TfNSW Reference: SYD23/00859/03
DPE's Reference: SSD-60513208

**ADVICE ON ASPECT INDUSTRIAL ESTATE STAGE 4 DEVELOPMENT (WAREHOUSE 8)
788-882 MAMRE ROAD, KEMPS CREEK**

Figure 1: Site Plan

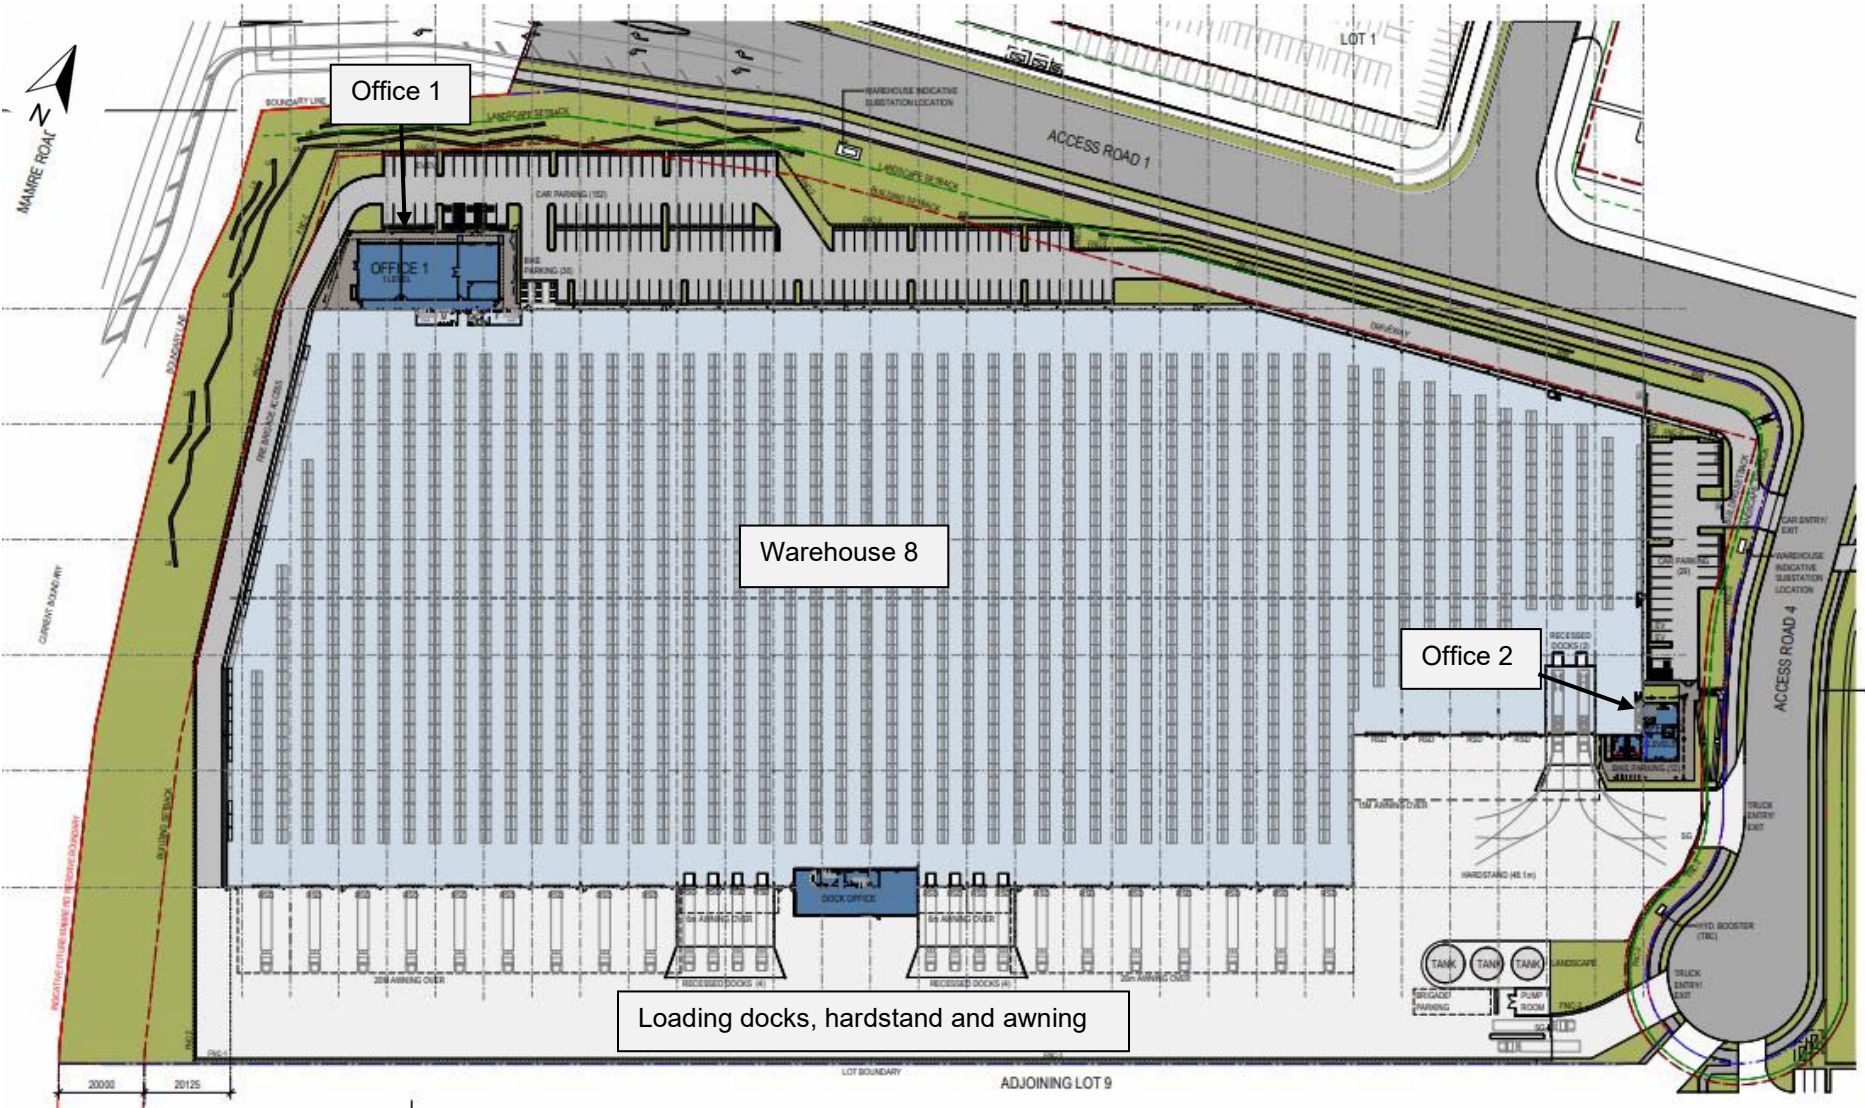
2. The proposed two car parks share single access off Access Road 4 and create conflict between vehicles accessing Car Park 1 and Car Park 2. The proposed light vehicle access needs to be modified to eliminate the conflict and improve the safety of road users.
3. The proposed light vehicle access is located too close to the intersection of Access Road 1 and Access Road 4. This access needs to be relocated further away from the intersection to ensure traffic efficiency of Access Road 1.
